RE: Submission to MP09_0066 MOD 3 Thomas Street Carpark, Chatswood

Thankyou for considering this submission in relation to the above modification application for the Thomas Street Carpark in Chatswood. The submission is made from the Executive Committee for Strata Plan 22904, 12 Thomas Street, Chatswood.

A-0100 C  
SECTION 75 W SUBMISSION

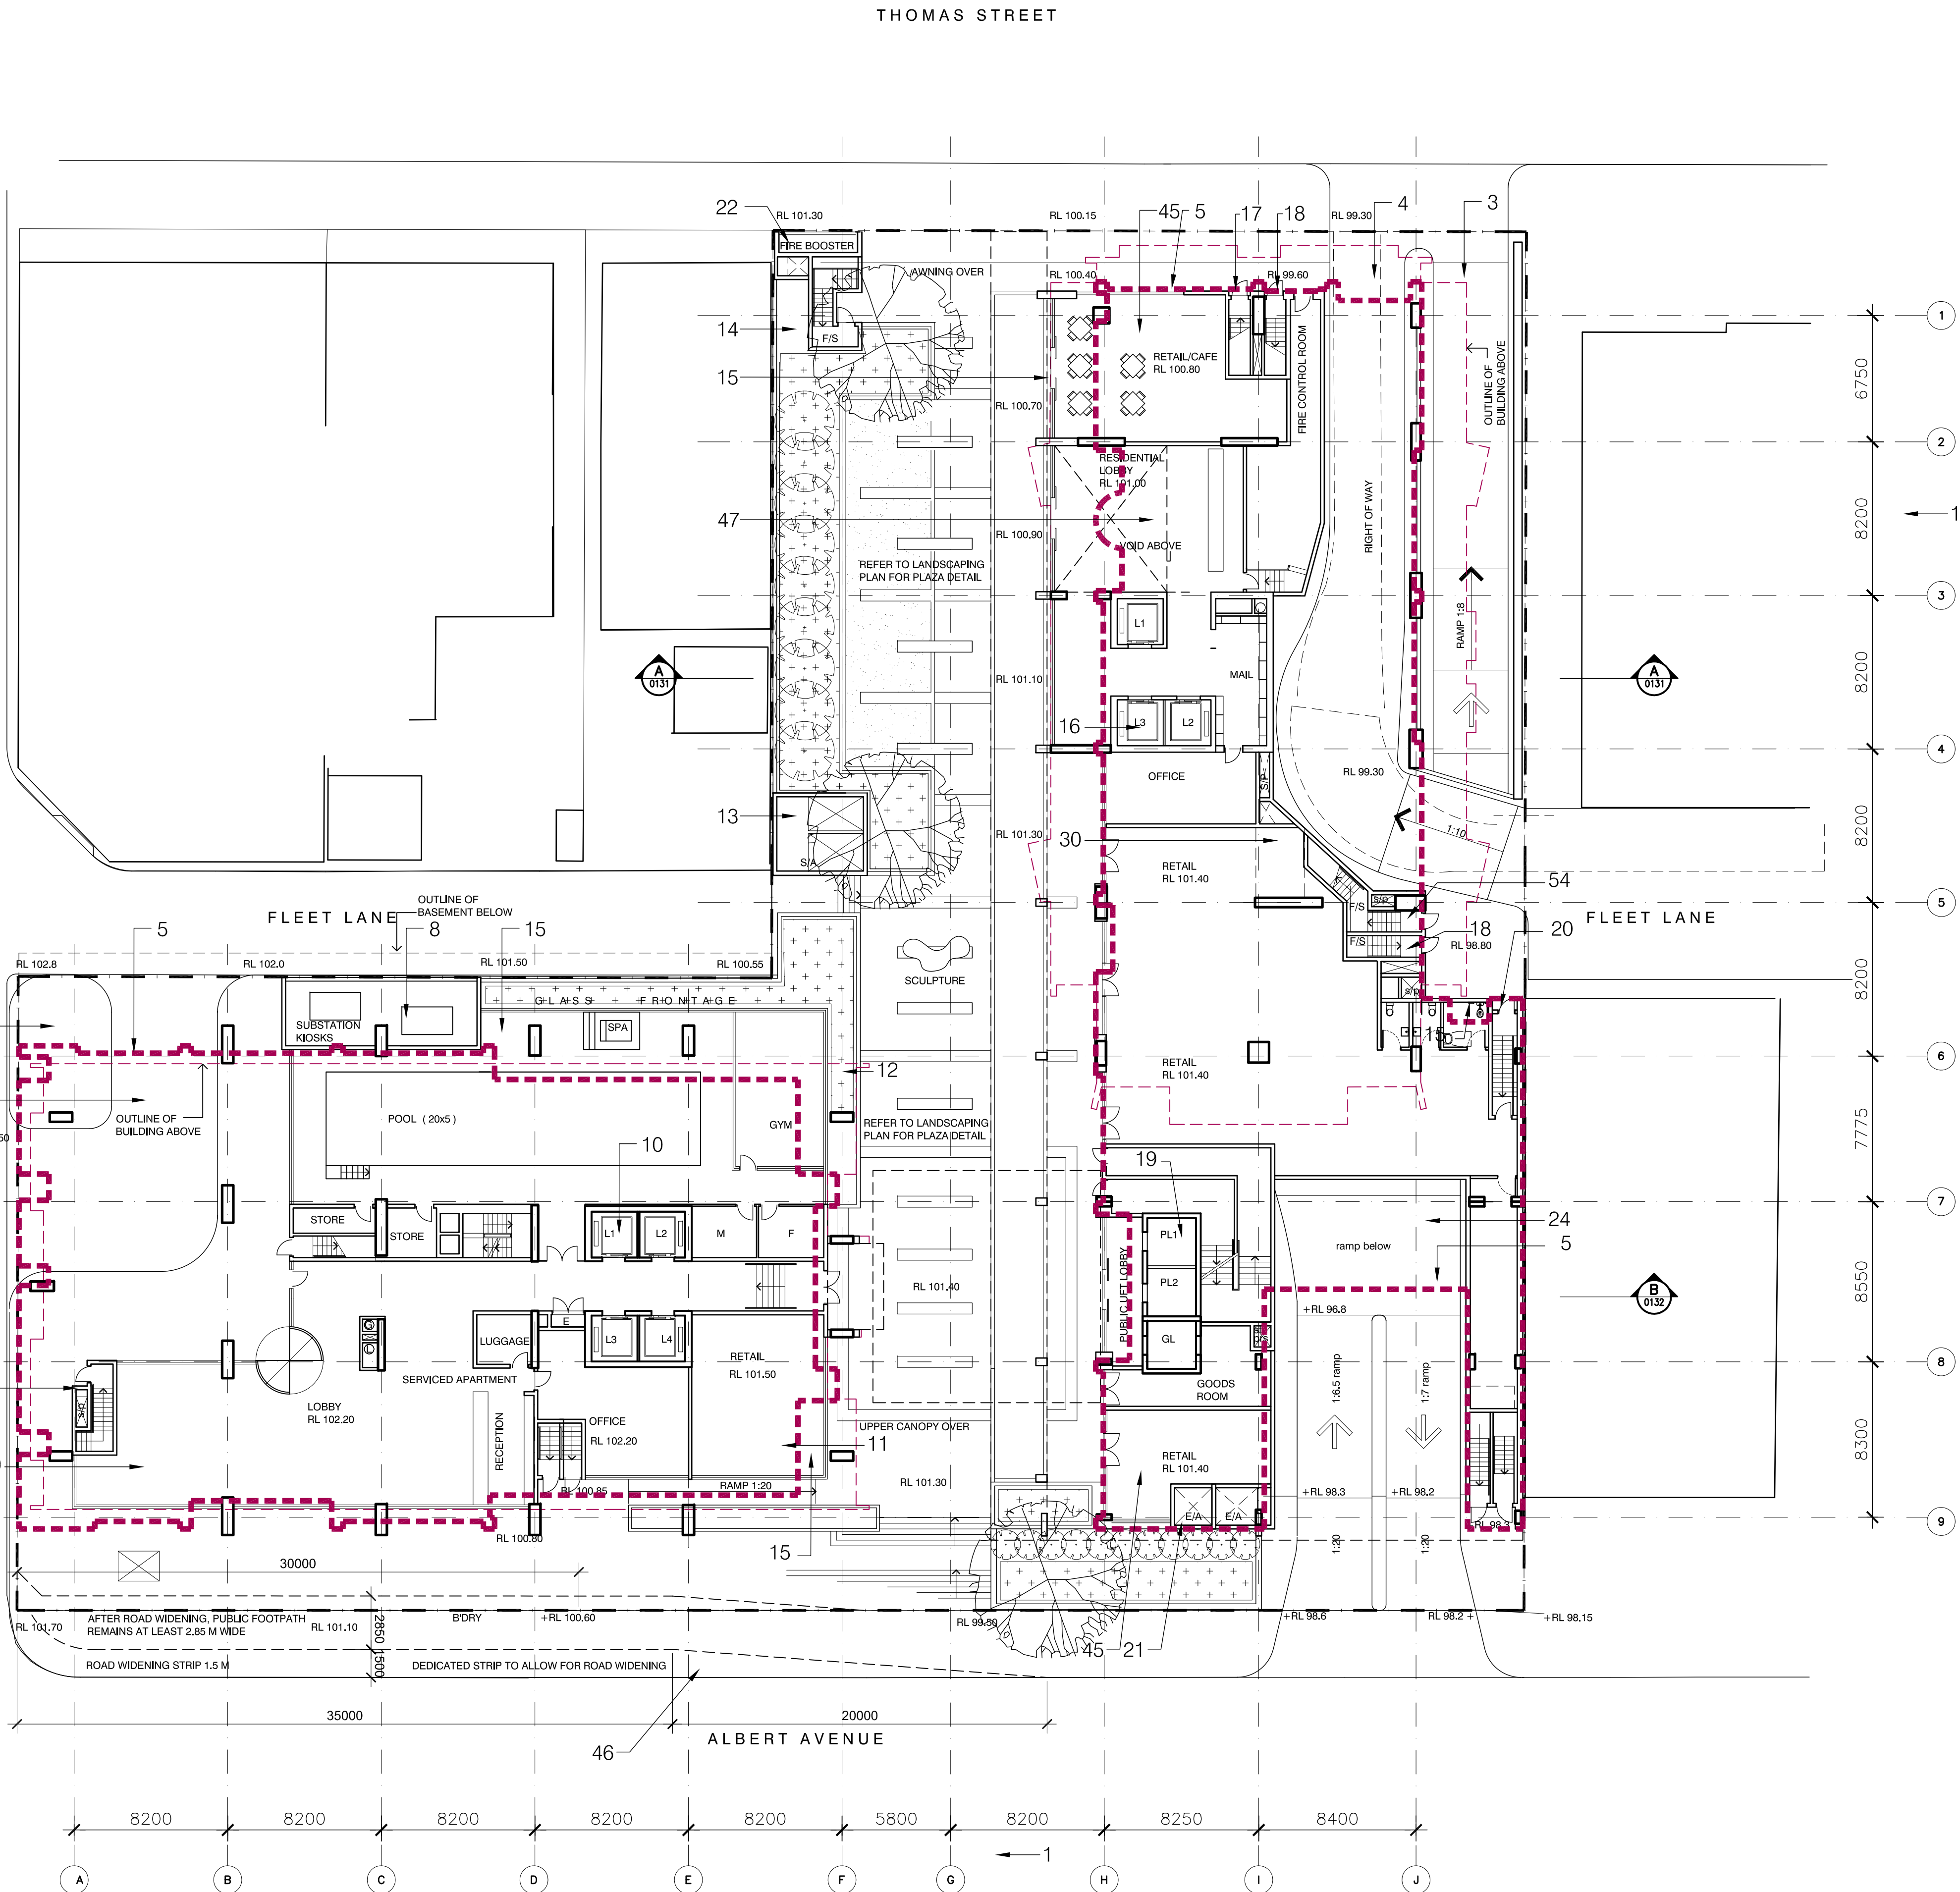
I don't understand what the proponent means by "Improved access connection from Thomas Street to Fleet Lane (southbound)" as part of the modifications.

It is my understanding that the ROW access arrangements off Thomas Street (beside 12 Thomas) shown in Figure 22 of the EAR, were superseded in the original development approval by plan no. SK002 dated May 2010. Despite this plan showing major access changes, the public was never given an opportunity to make any submission or comment on the changes. The changes directly affect 12 Thomas Street.

The design of the ROW raises issues of security and safety, particularly for disabled access (discussed in more detail below). This is now further compromised by the location and design of the proposed childcare centre, which overhangs the entrance and corner of the ROW where it joins with Fleet Lane.

What is the reason for changing the ROW direction of traffic on the ground floor plan lodged with MOD 3 from the approved plan SK002?

Is there enough height under the Level 1 childcare centre for the garbage truck that services 12 Thomas Street?

The proposed egress ramp onto Thomas Street from the basement carpark pushes the proposed shared ROW further under Building 1, in effect, making it a tunnel between the corner of Fleet Lane and Thomas Street. This raises several issues.

It appears from the plans that the childcare centre hangs over the ROW into Fleet Lane right up to the boundary of 12 Thomas St. It will look unsightly and we strongly object to this. The existing setback to 12 Thomas Street should be maintained.

NORTH ELEVATION
A-0121 **C**
SECTION 75 W SUBMISSION

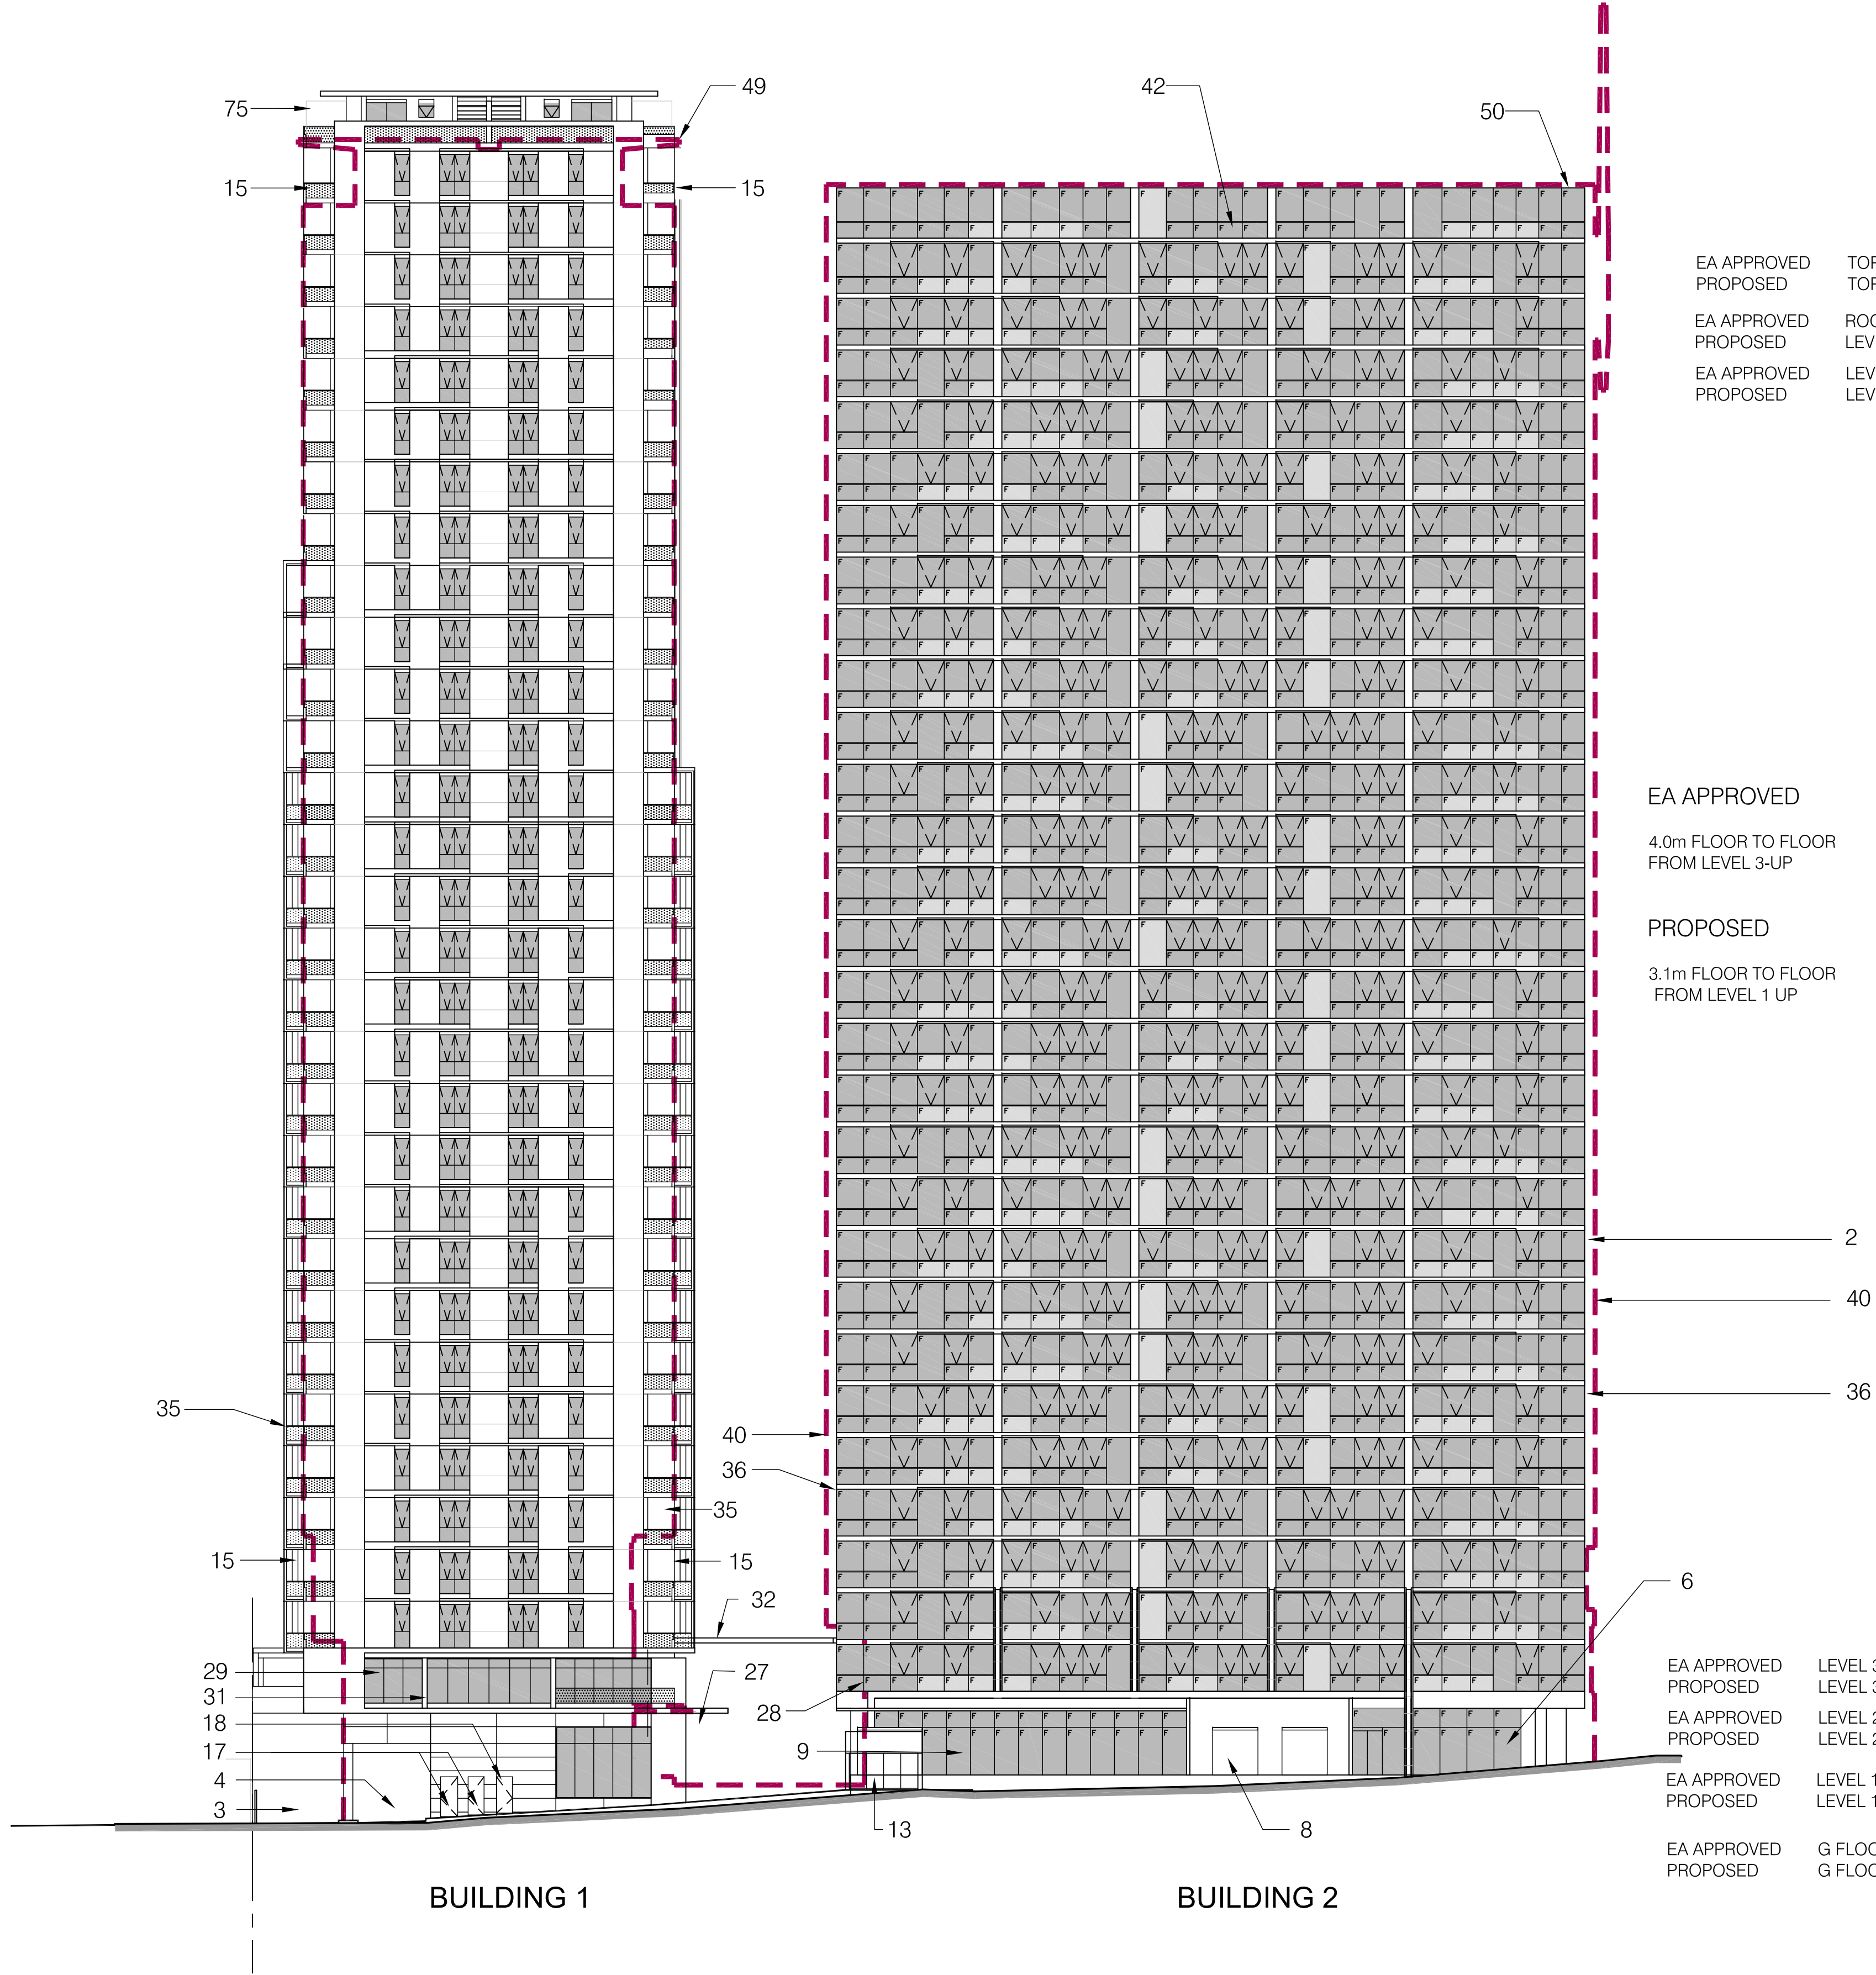
In addition, the elevation plans lack detail. There is no elevation showing the location of 12 Thomas Street in relation to the tower and proposed changes and height comparisons.
